COPPER CHASE AT STERLING RANCH

CONSTRUCTION PLANS

AUGUST 2023

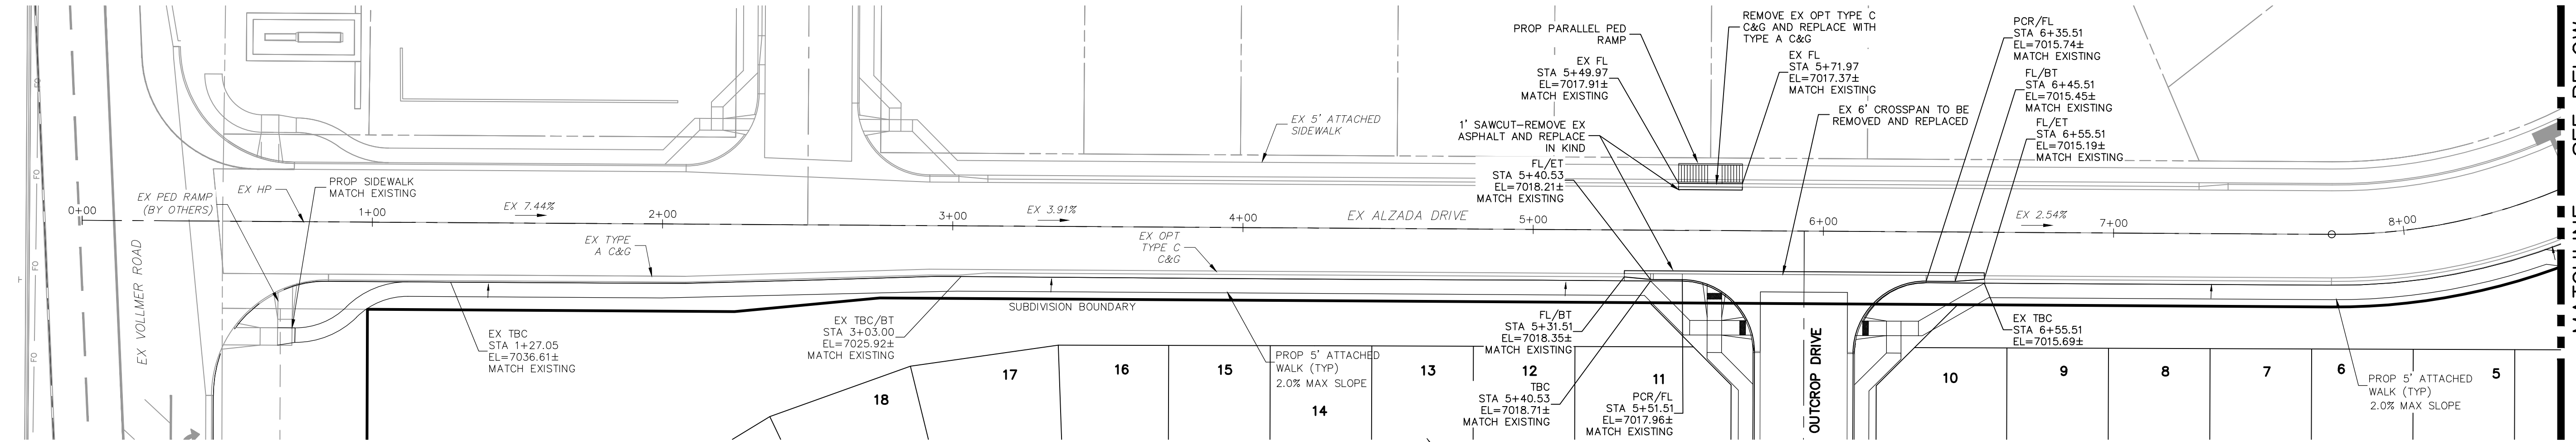
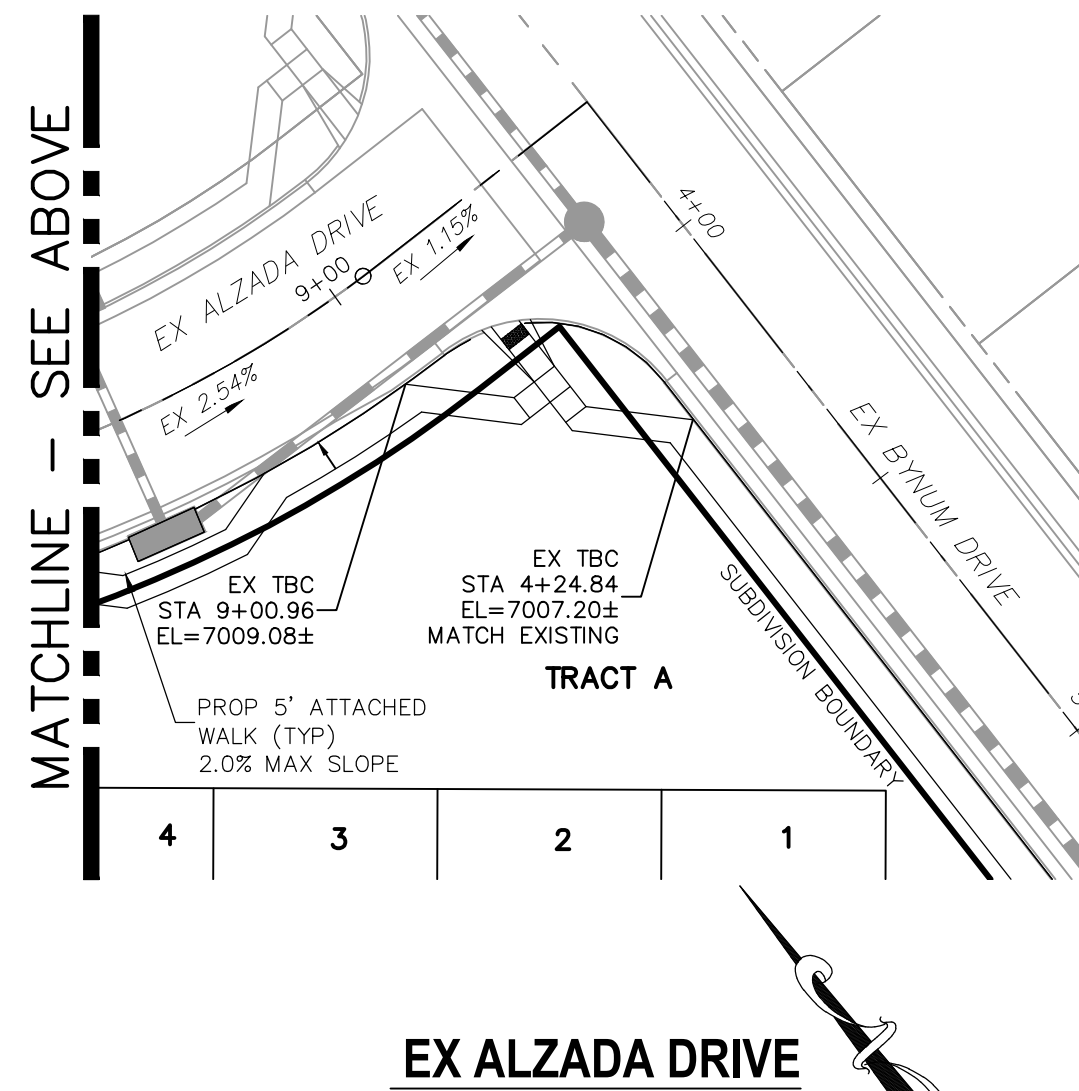
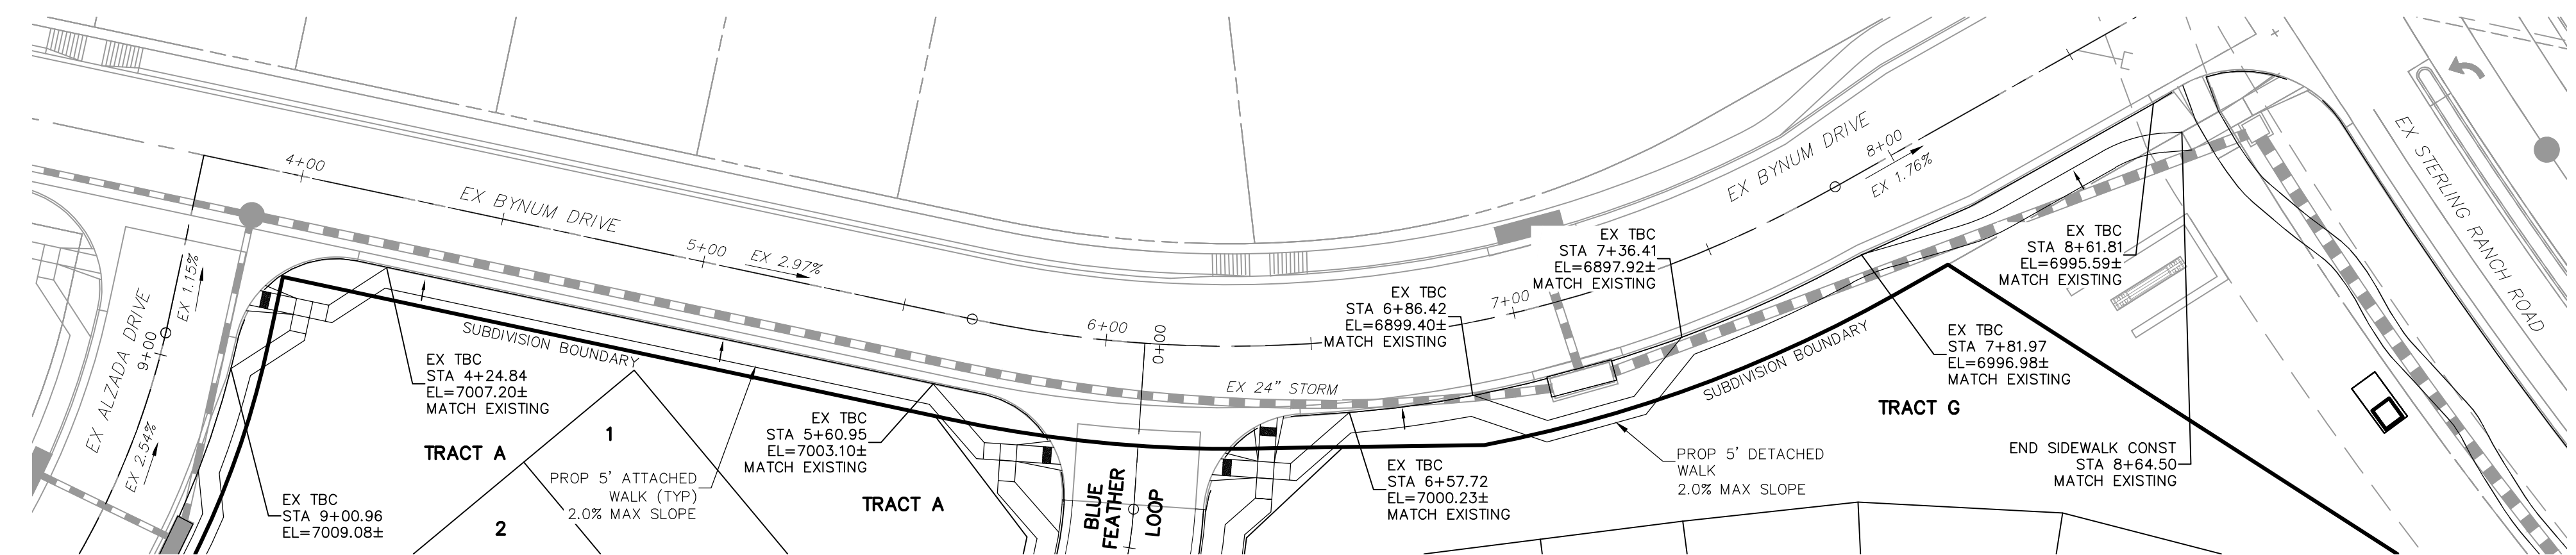
Sidewalk should run behind inlet unless an integrated design is provided. ADA requirements apply. Staff strongly suggests sidewalk behind inlet to avoid settlement issues between sidewalk & inlet.

Sidewalk adjusted
